# Notes of 3/15/18 MMC Check-in Mtg- Detour issues; Schedule & Communication Plan

Key points from the 3/15/18 Site Plan Review meeting with MMC:

# Notes of 2/15 MMC Site Plan Review Meeting (CMP/Detours)

# <u>Congress Street Closure</u> and associated detours/emergency access (based on the revised docs and plans attached to this e-mail from Gorrill-Palmer)

Boynton Street Detail

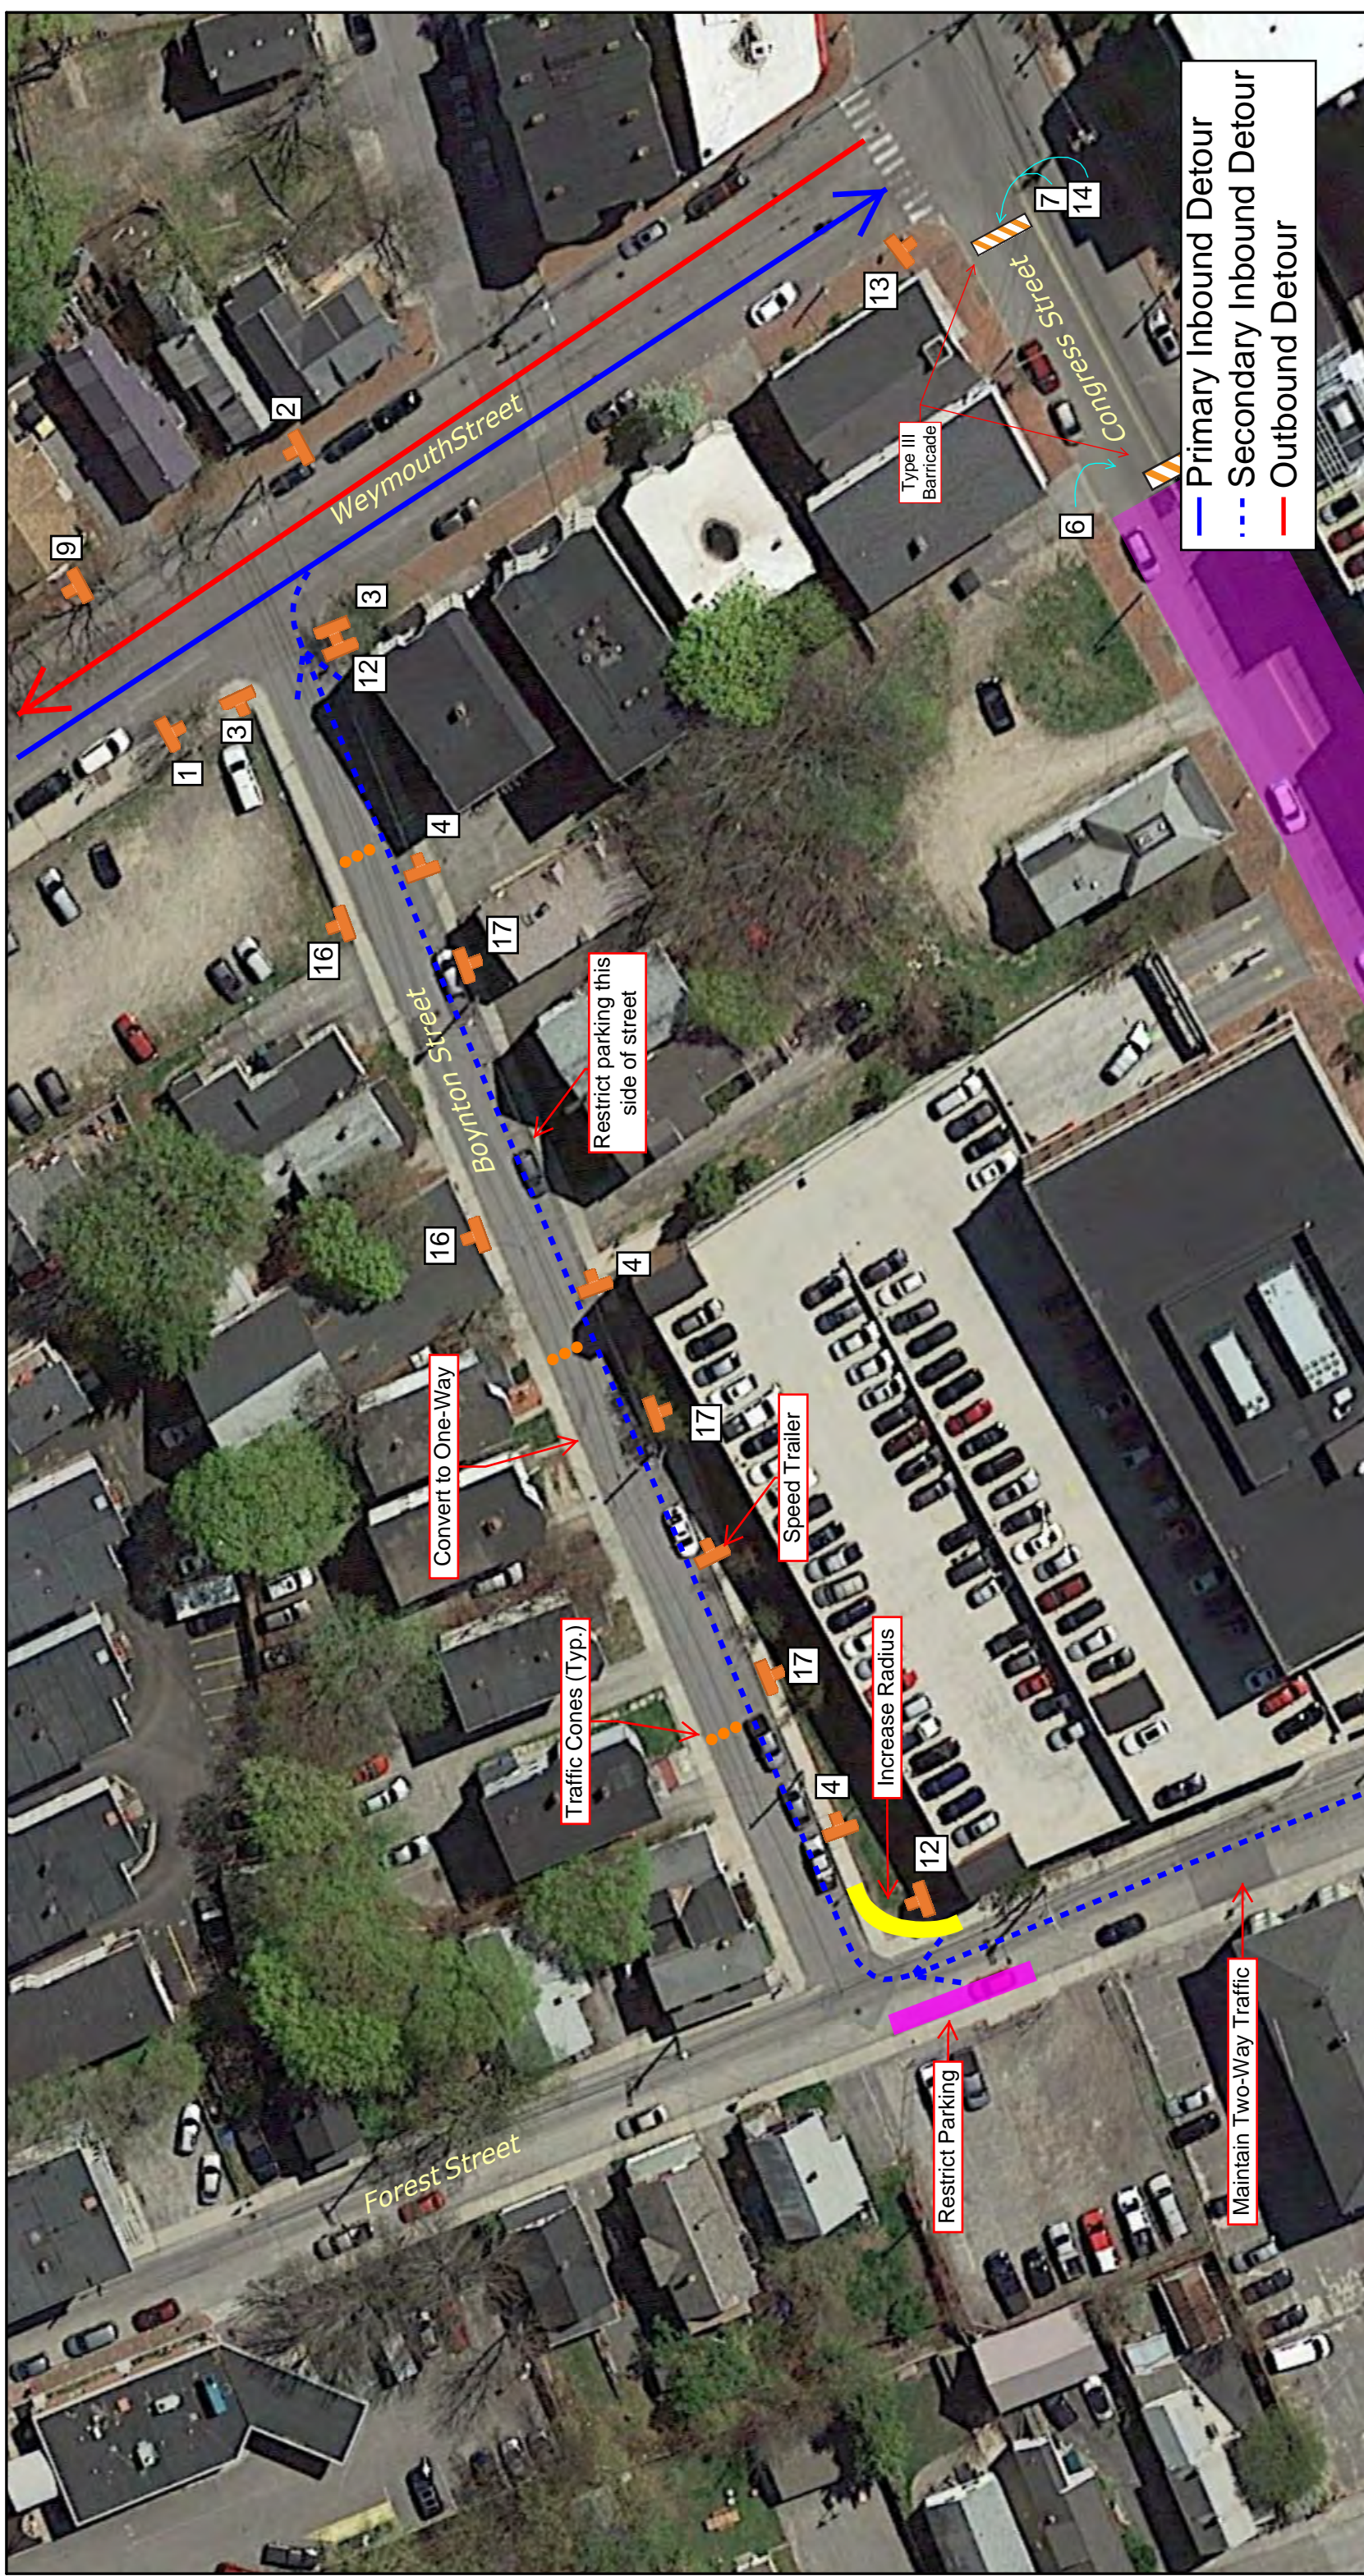
- Regarding the turning radius at Boynton/Forest, KG and TE both were concerned and requested seeing turning template of a fire truck making the right turn into Boynton from Forest
- UPDATE: 3/16 RD of G-P had done the autoturn and MMC has concluded they need to modify that radii and it will be part of the updated MOT that will be in the PB Packet

Congress Street Detail

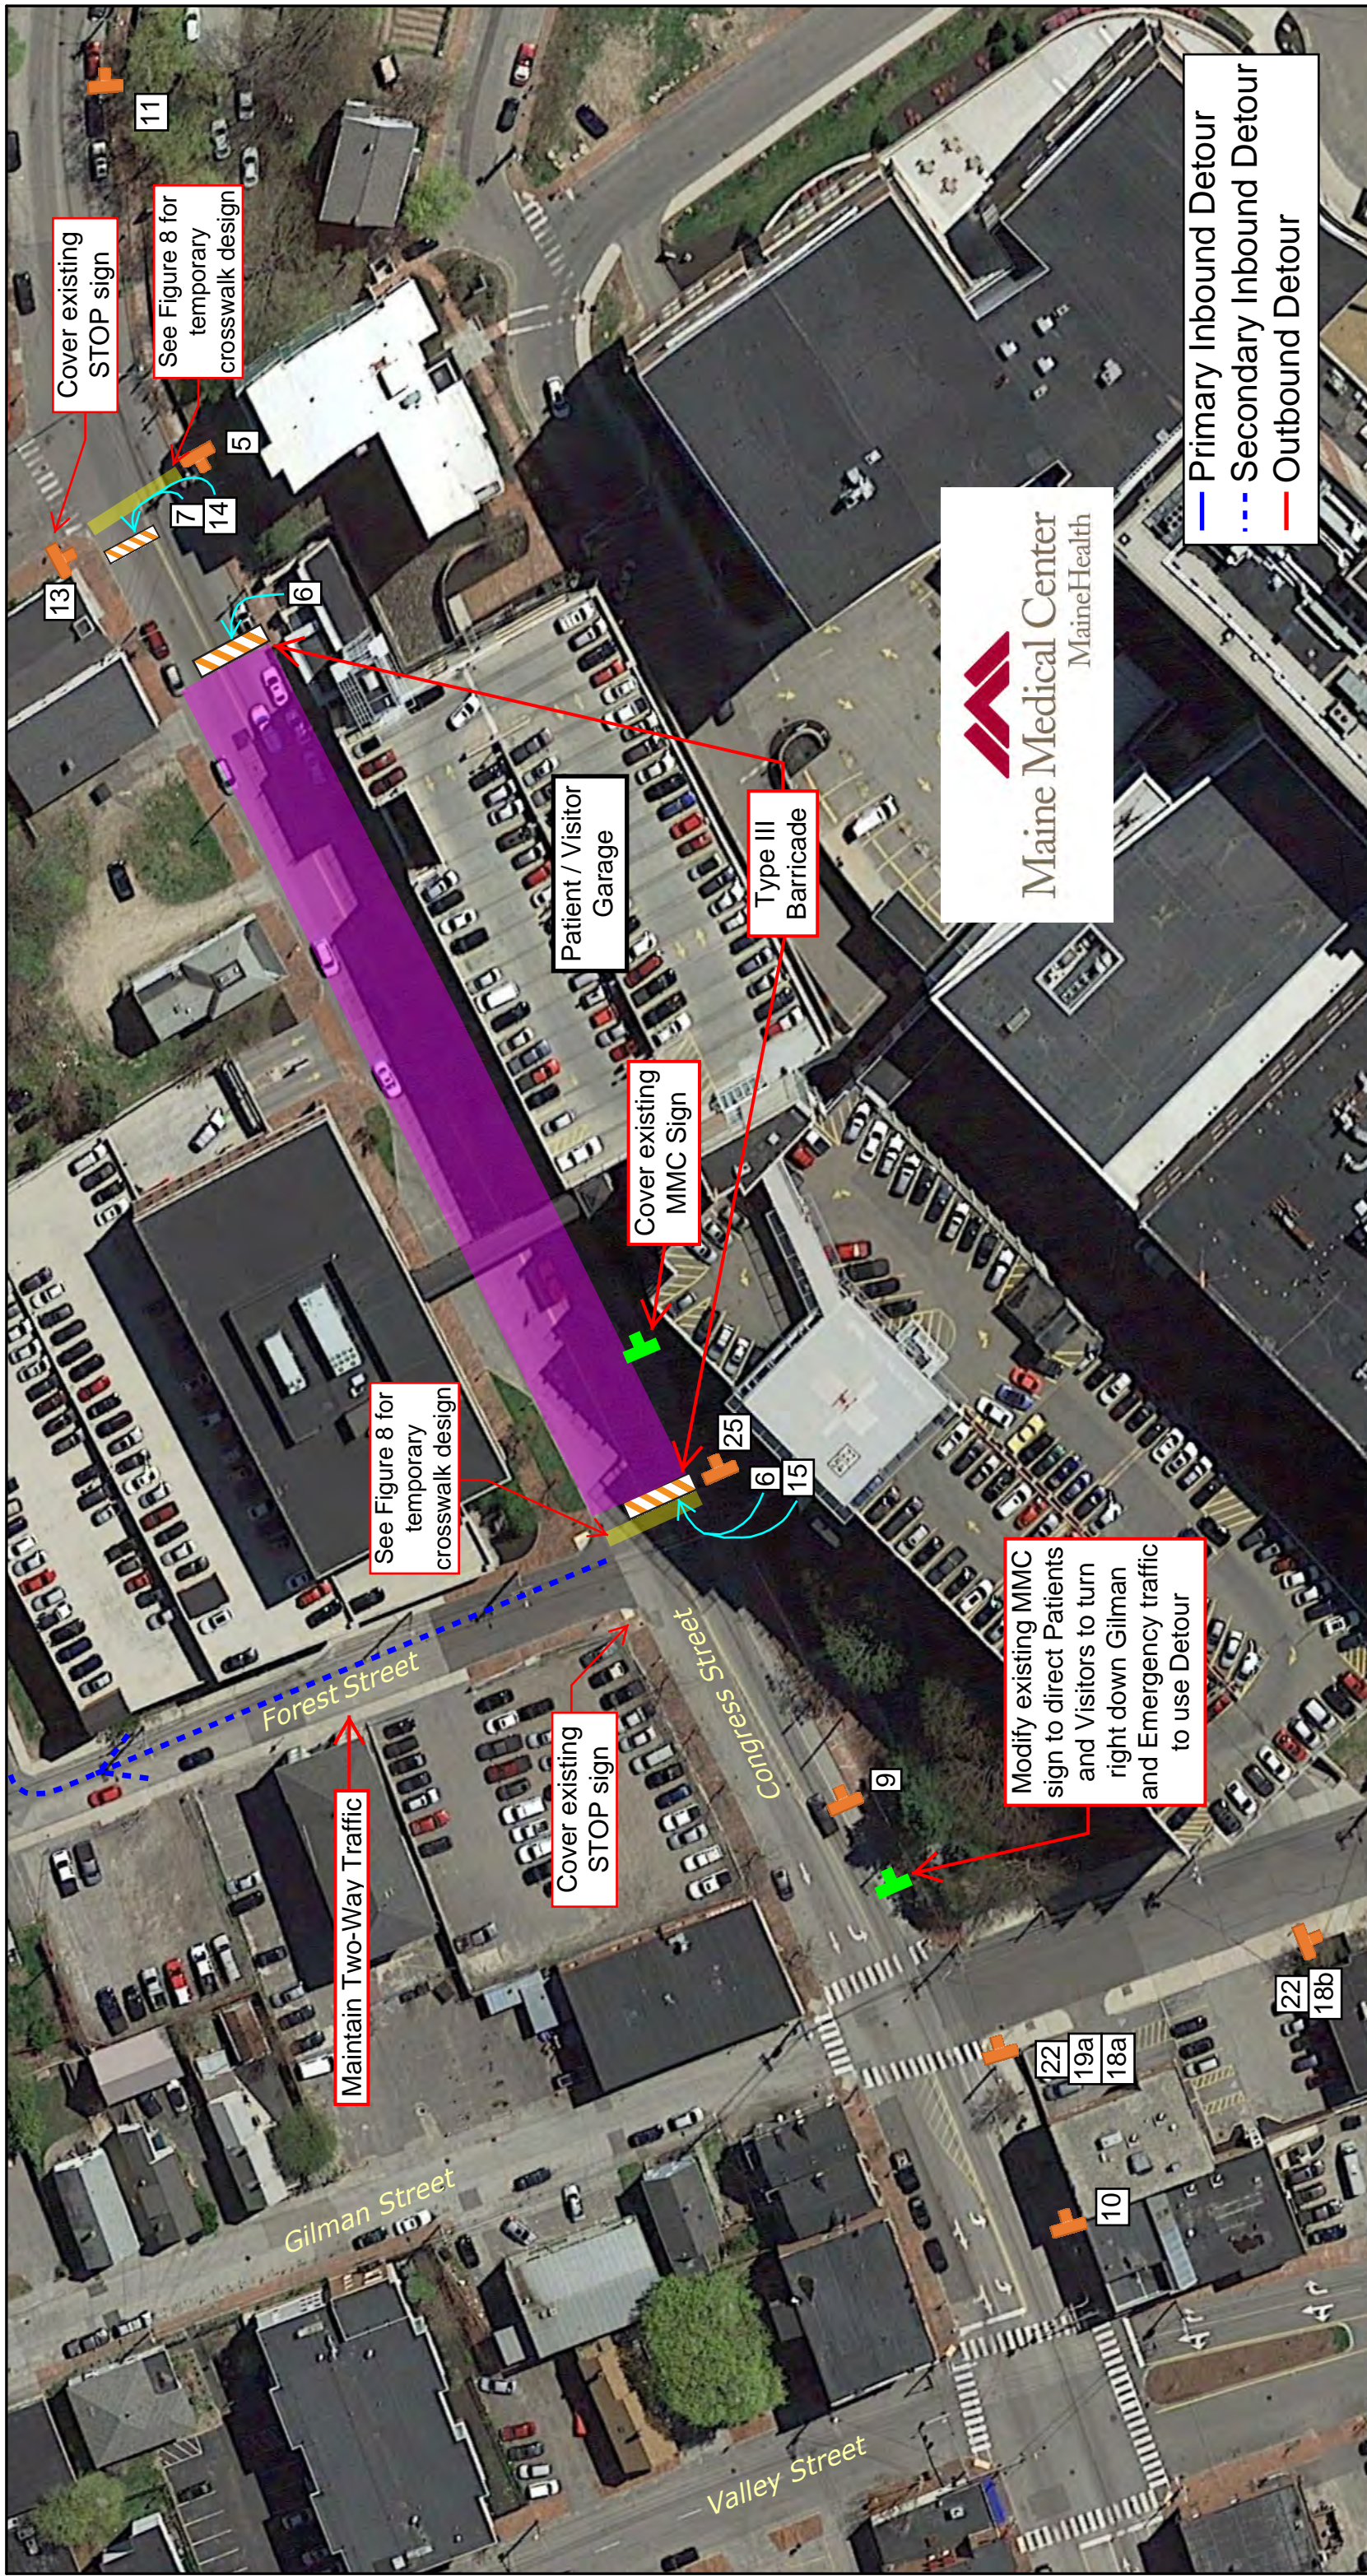
- Short section of outbound lane to be left open in front of MOB for access for ambulances etc
- Police concerned re night issues here

METRO Modifications Due to Congress Street Closure

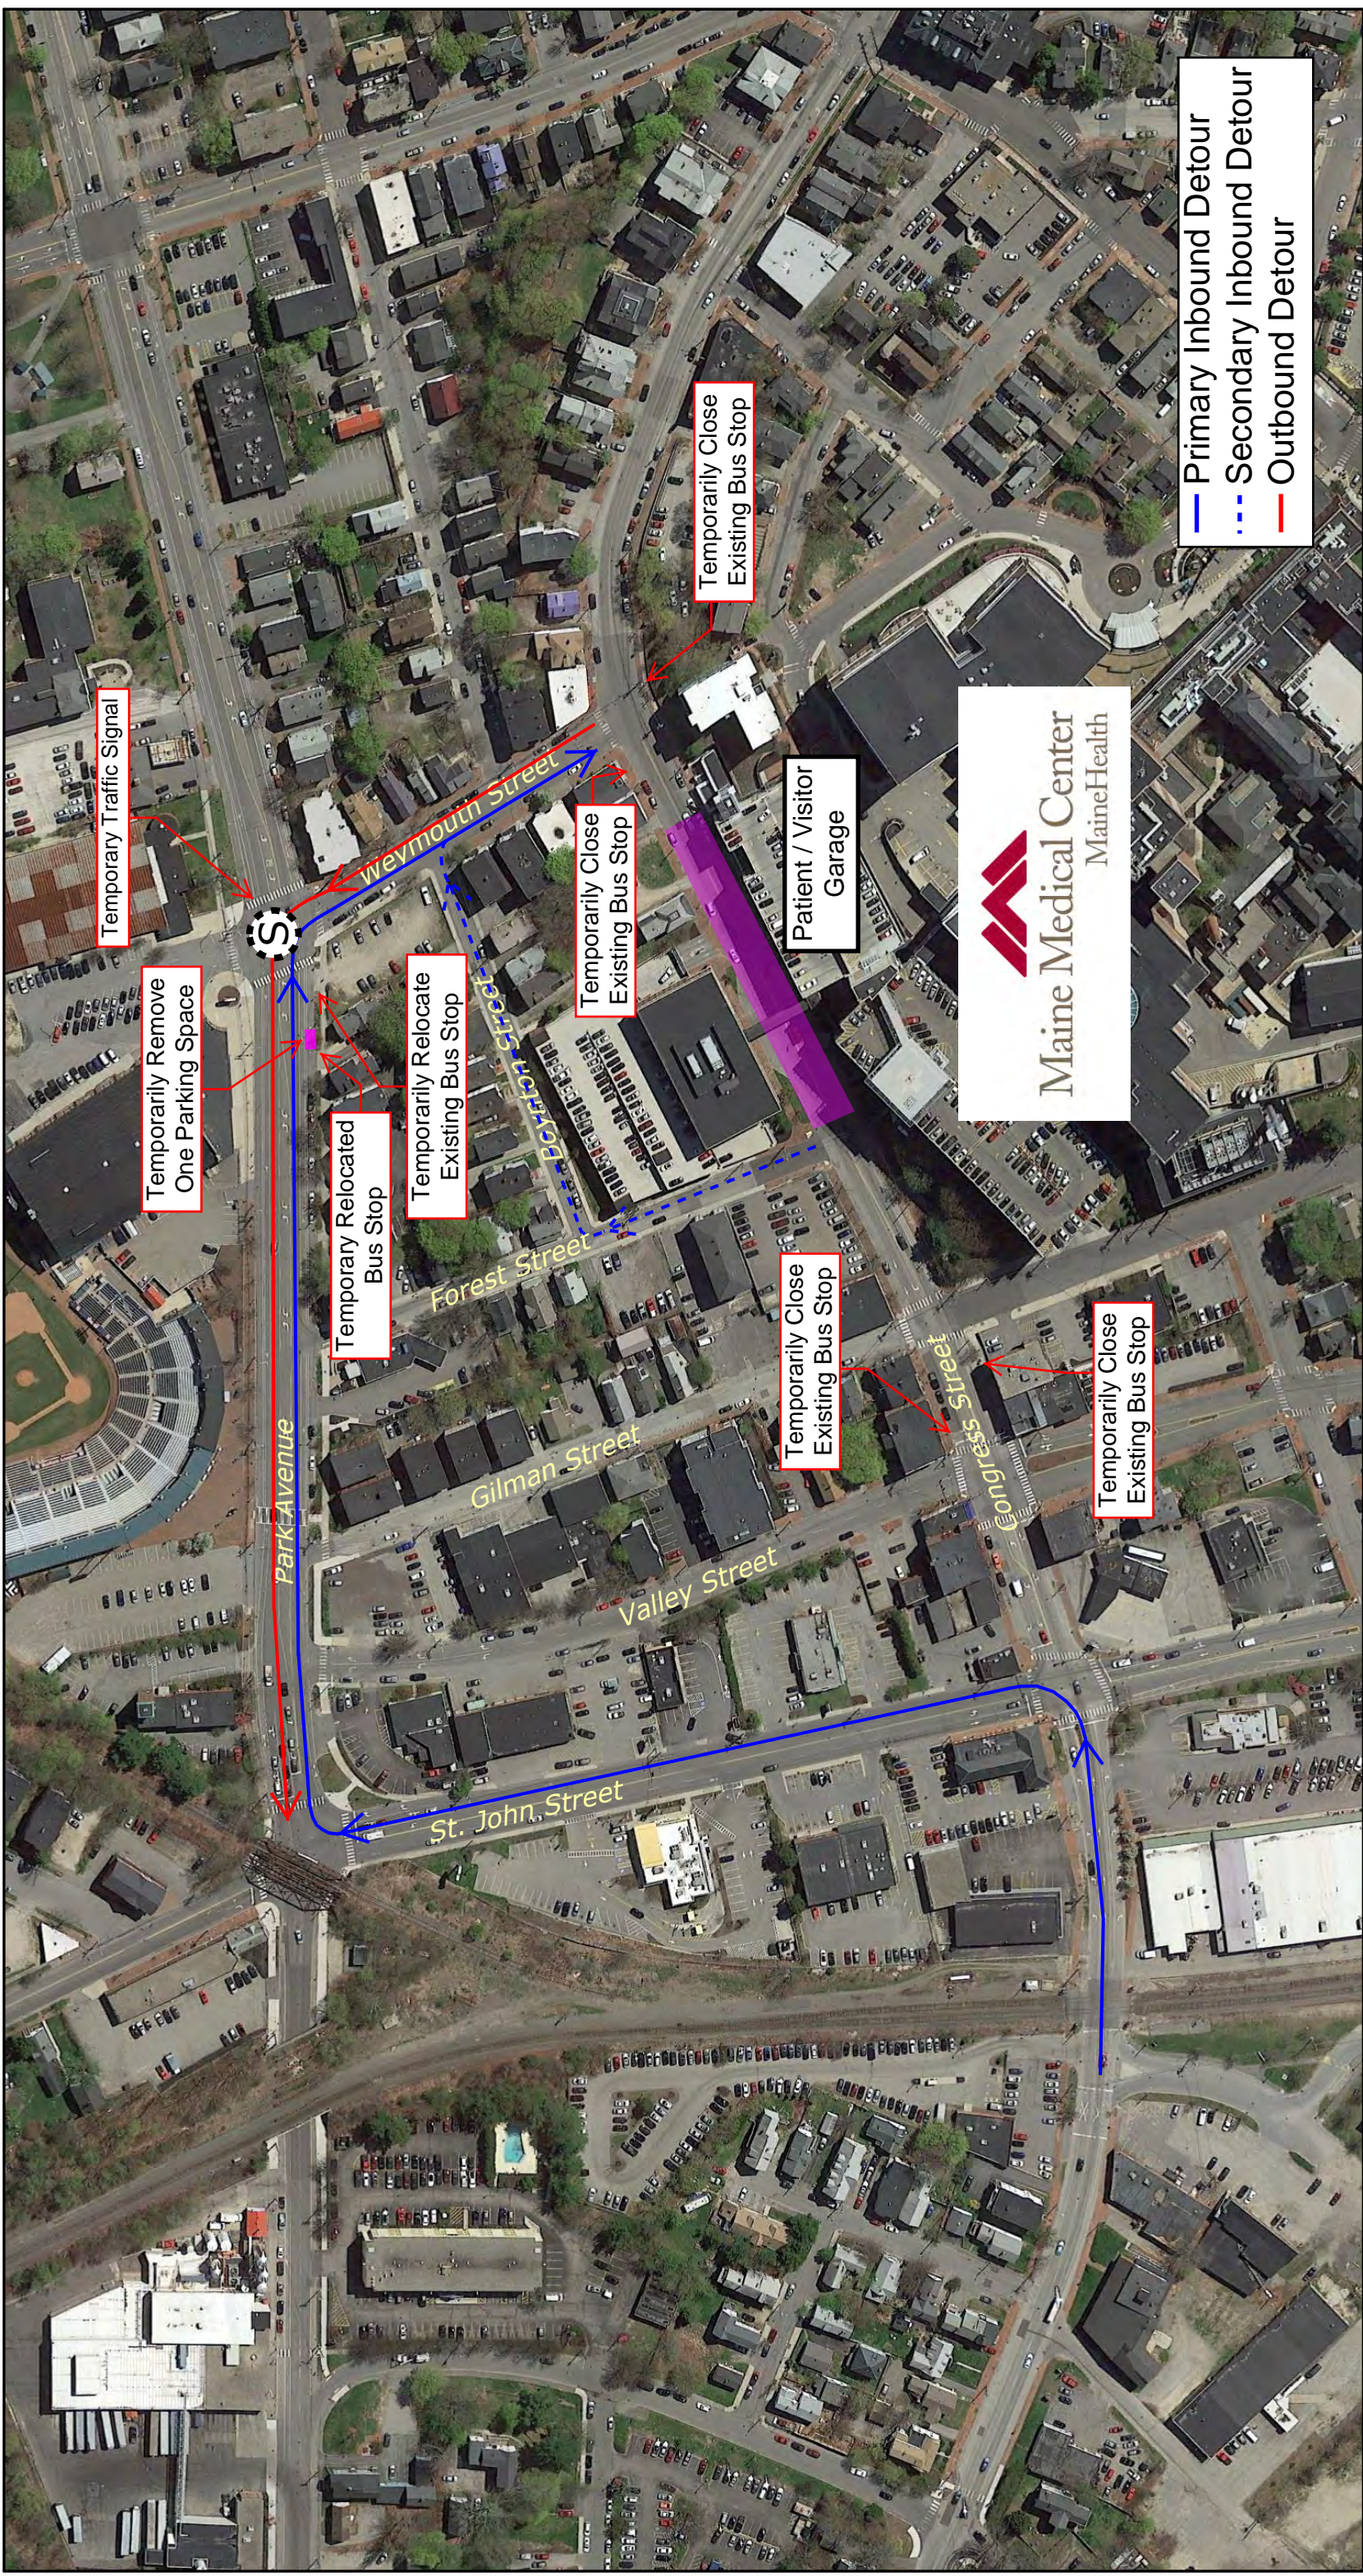
- Metro had requested that the stop be relocated about 40 feet west and have a concrete slab created between the curb and sidewalk for bus passengers
- Note that parking spaces would need to be removed but DPW have authority to close 2 parking spaces
- Question as to whether METRO would want the stop and pad to remain permanently - if not, is it worth pouring the pad? BH to check with METRO
